Re: Traffic Noise Addendum
377-381 Winona Avenue, Ottawa, ON
Gradient Wind File No.: 22-293-Addendum Letter

Gradient Wind Engineering Inc. (Gradient Wind) was retained by Azure Urban Developments to undertake a roadway traffic noise brief for the proposed six-storey mixed-use development located at 377-381 Winona Avenue in Ottawa, Ontario (*ref. GW22-293-Roadway Traffic Noise Brief, dated October 12, 2022*). This addendum letter addresses technical comments received from the City of Ottawa in February 2023. This letter is to respond to the following comments received from the City of Ottawa via e-mail correspondence in February 2023, and to provide supplemental analysis for the original roadway traffic noise brief. The comments are numbered per the numbering sequence in the e-mail correspondence.

DESCRIPTION	FIGURE 3: STAMSON INPUT PARAMETERS
-------------	---------------------------------------

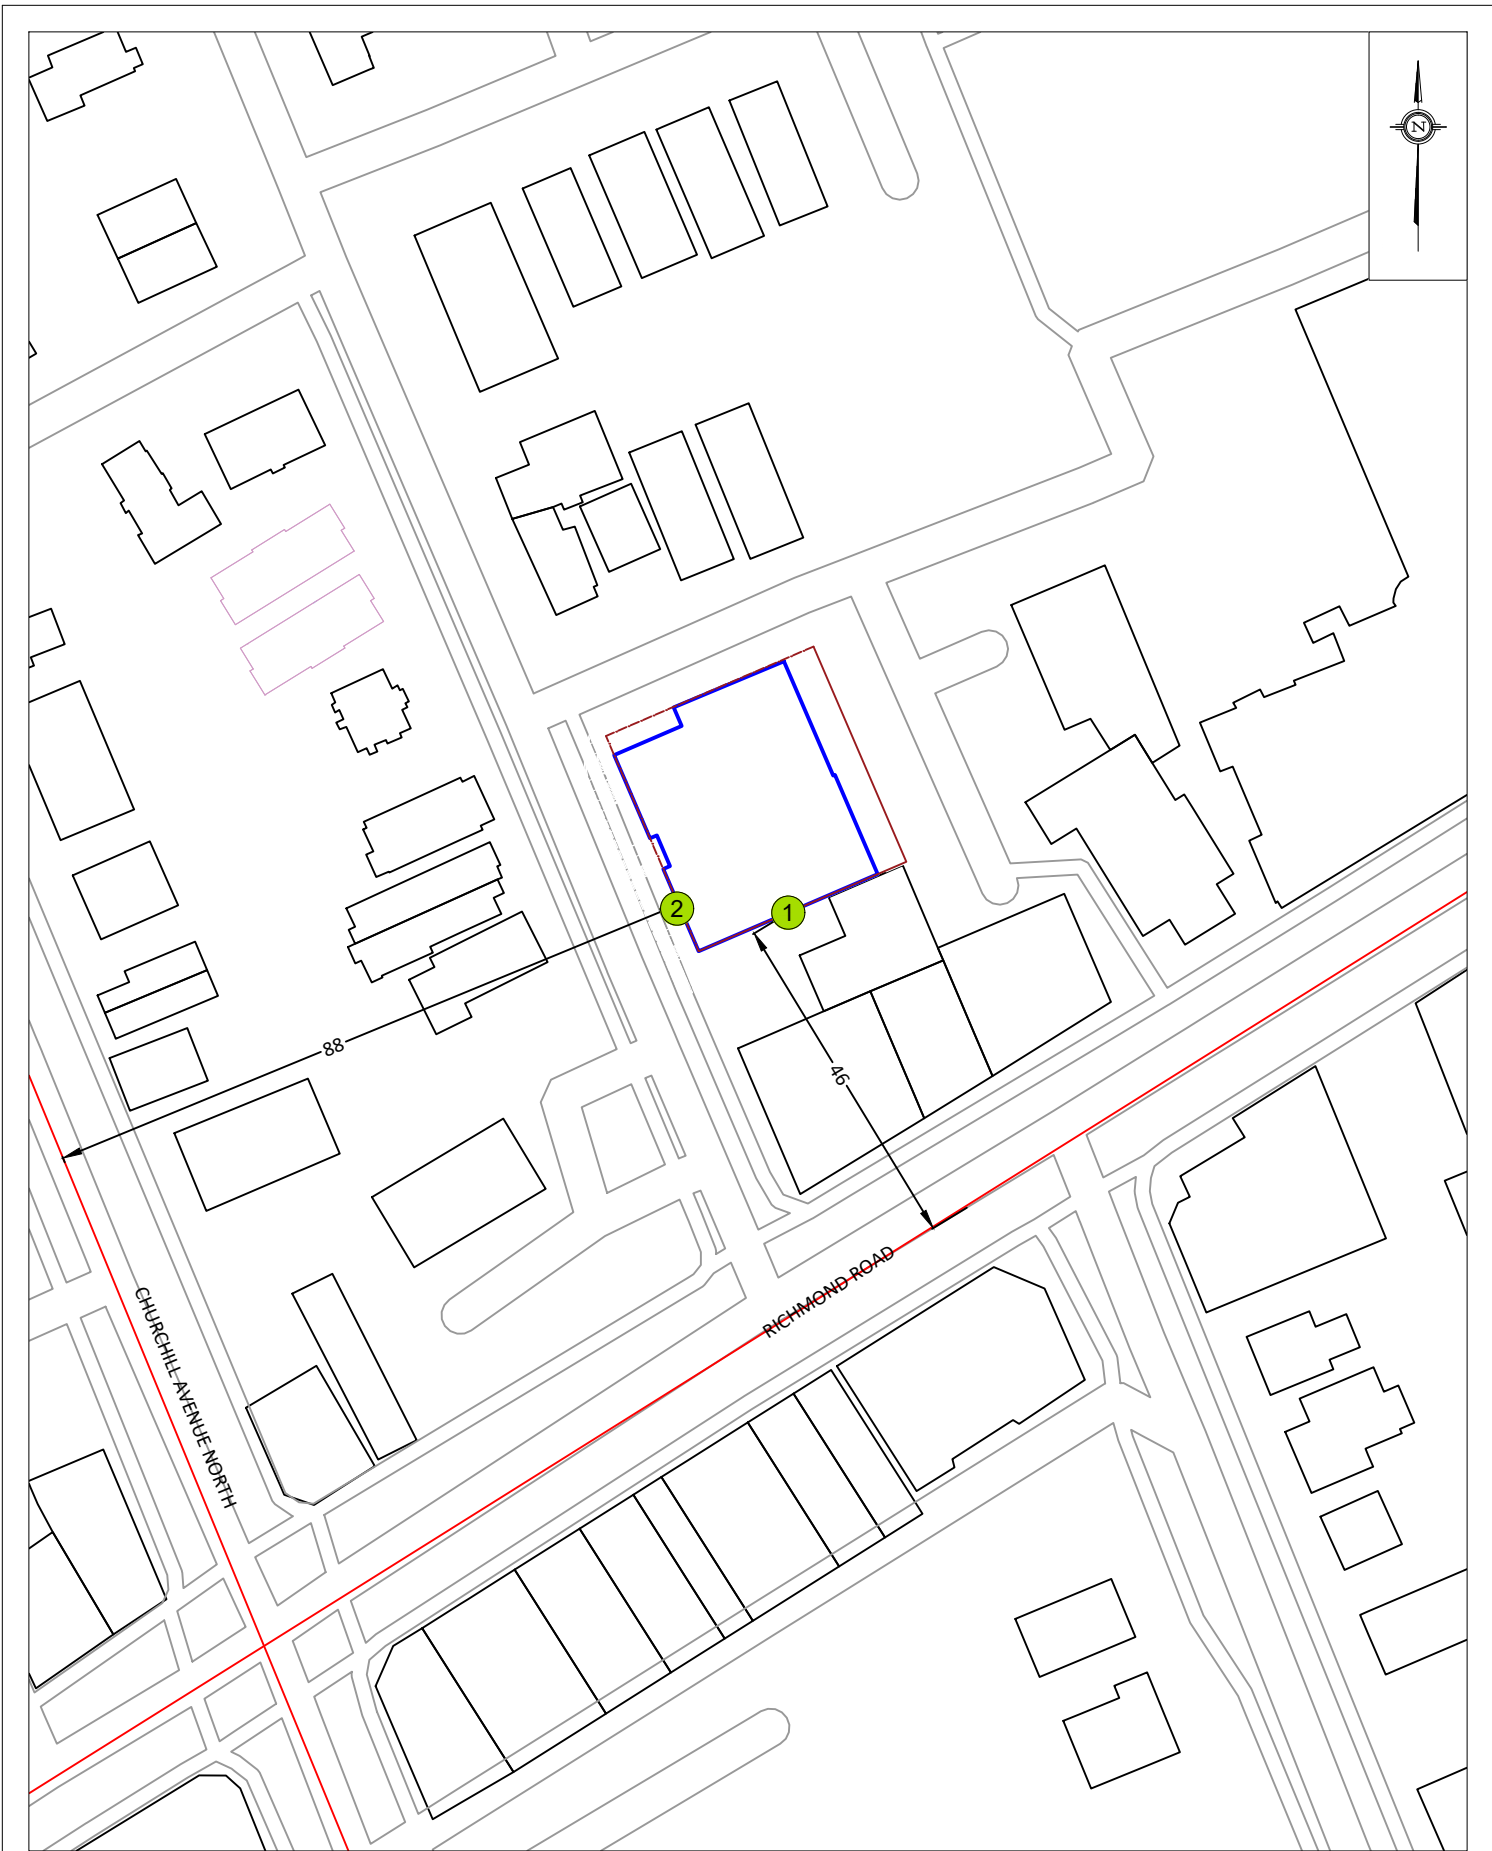
Comment 25: *What is the posted speed limit on Richmond Road and Churchill Avenue North? When there is no posted speed limit, please use 50km/hr. for the analysis.*

Gradient Wind: Using a traffic speed of 50 kph on Richmond Road and Churchill Avenue North, compared to 40 kph, there will be a minor noise level increase of approximately 1 dB. This update will not have any impact on the conclusions of the original report, as noise levels at the plane of window will change from 61 to 62 dBA, remaining below the 65 dBA threshold. This can be demonstrated logarithmically as follows: $10 \text{ dBA} * (\log(50 \text{ kph}/40 \text{ kph})/\log 10) = 0.97 \text{ dBA}$. This has also been confirmed within the STAMSON calculations.
